From:Wheeler, Alan
Sent:Thu, 21 Jan 2021 15:01:01 +0000
To:Planning
Subject:RE: Planning Application Consultation ref 21/00024/FULL at Land To East Of 95A Beryton Road Gosport Hampshire

From: Planning
Sent: 20 January 2021 16:26
To: StreetScene
Subject: Planning Application Consultation ref 21/00024/FULL at Land To East Of 95A Beryton Road Gosport Hampshire

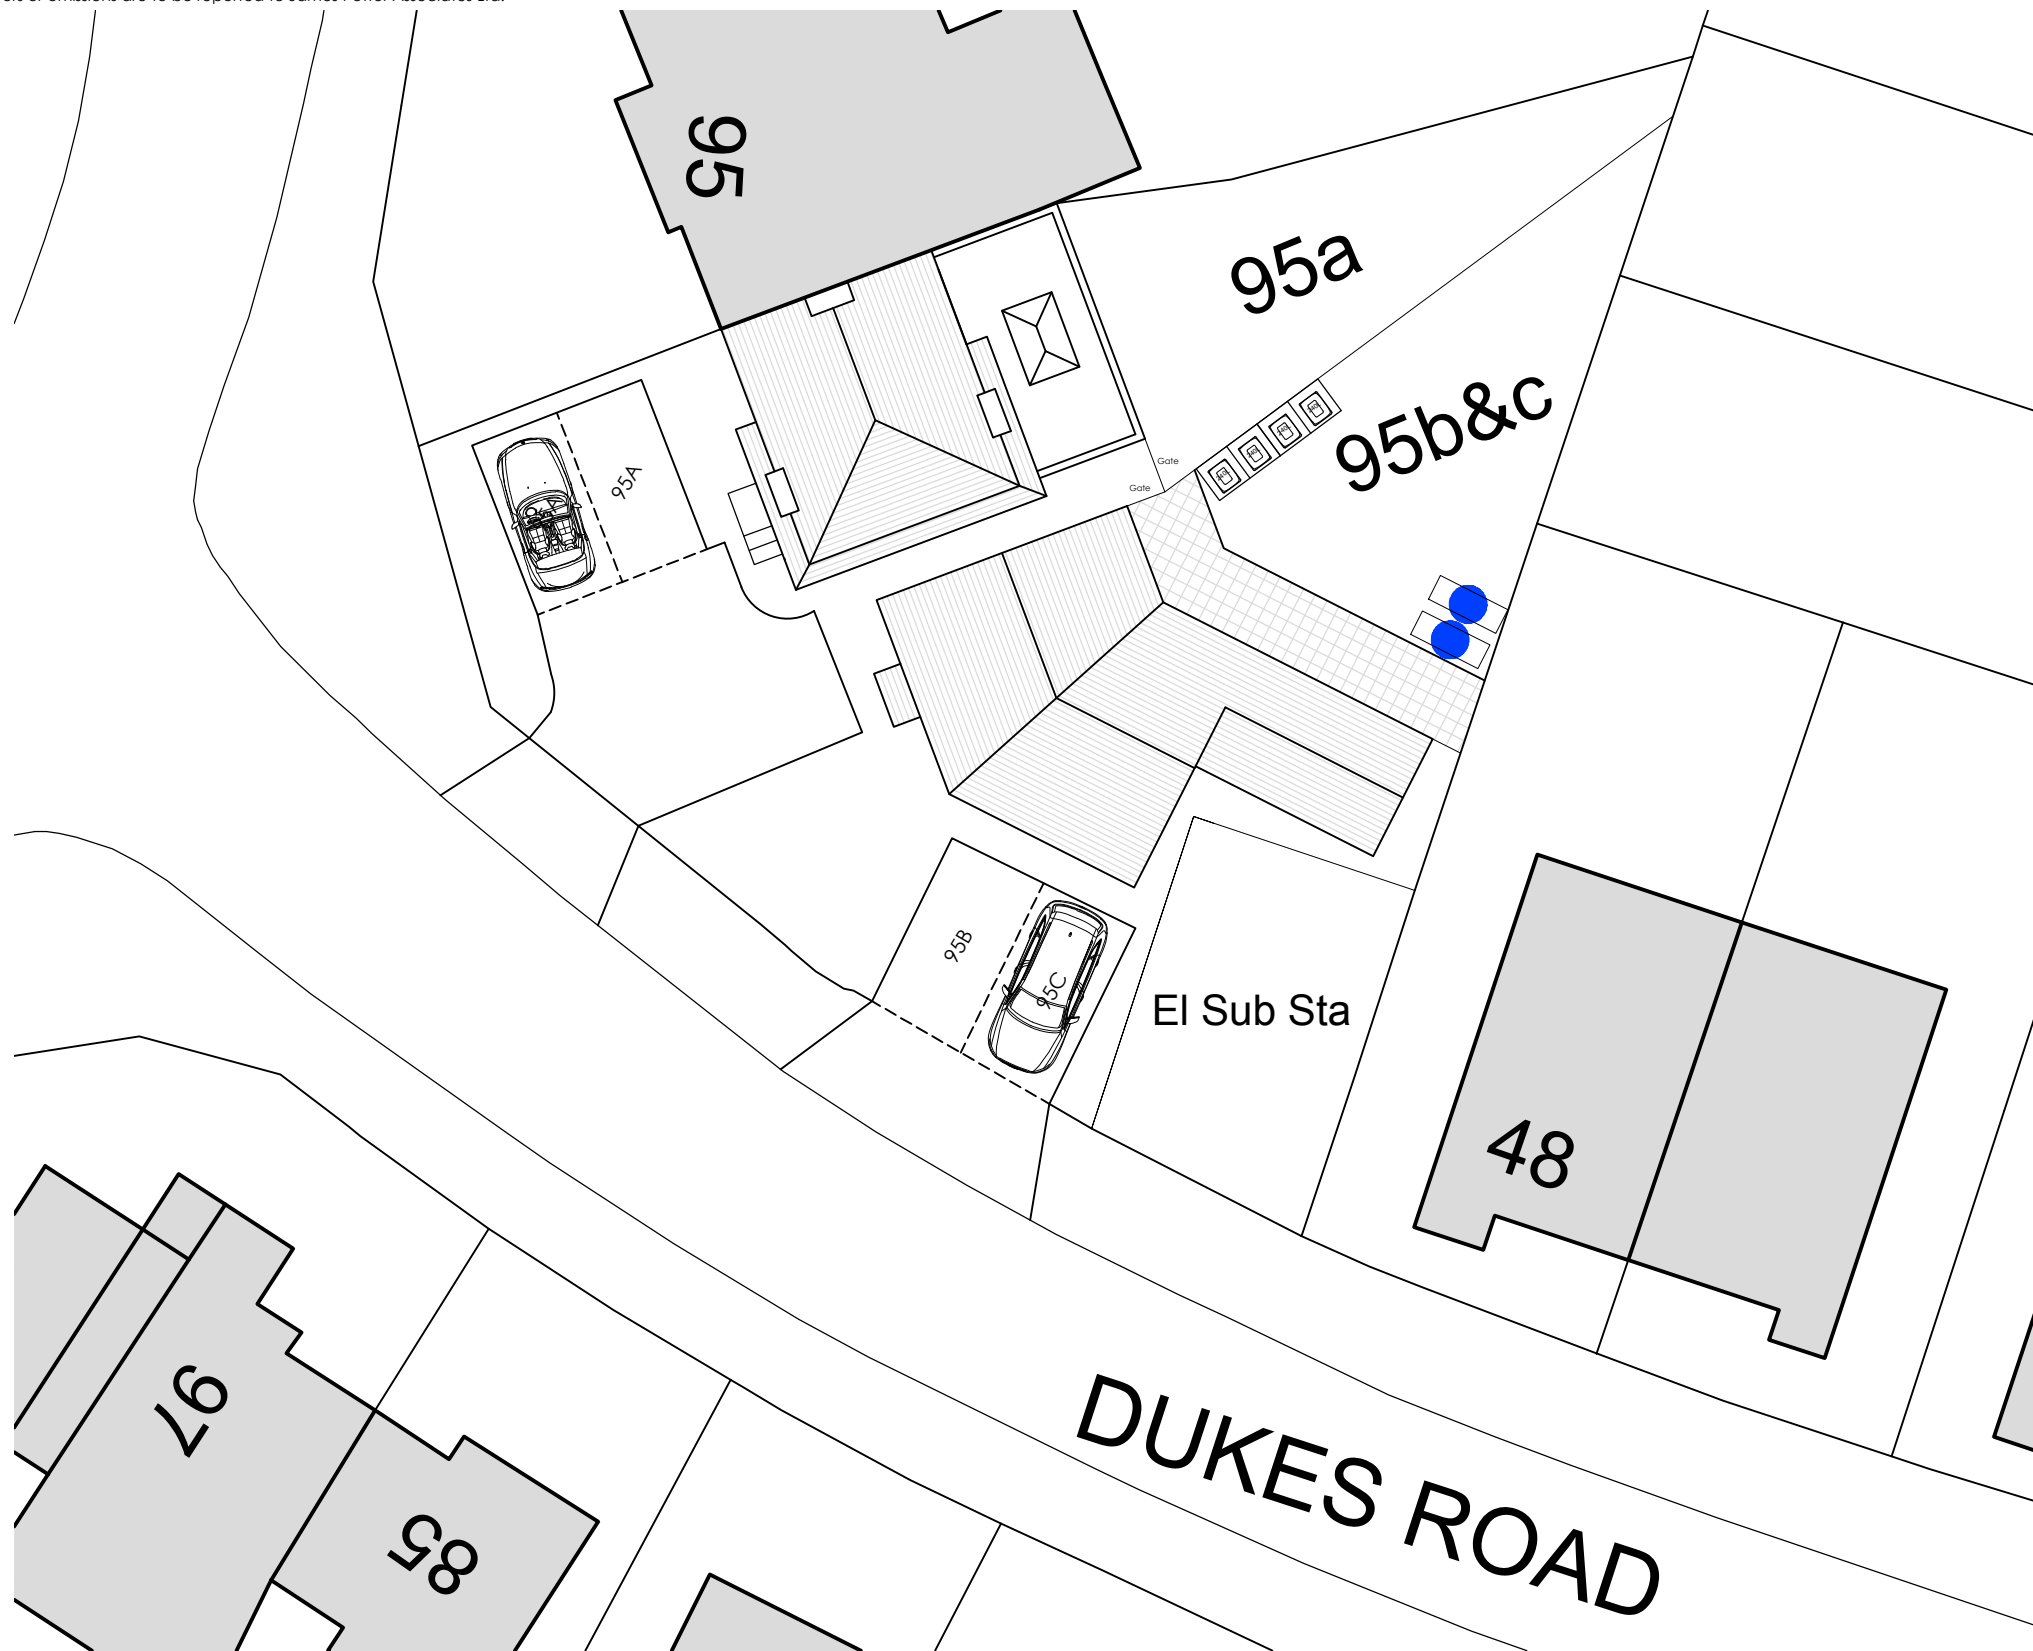
Adequate storage arrangements shown for the required bins which will be presented kerb-side Beryton Road to facilitate collection.
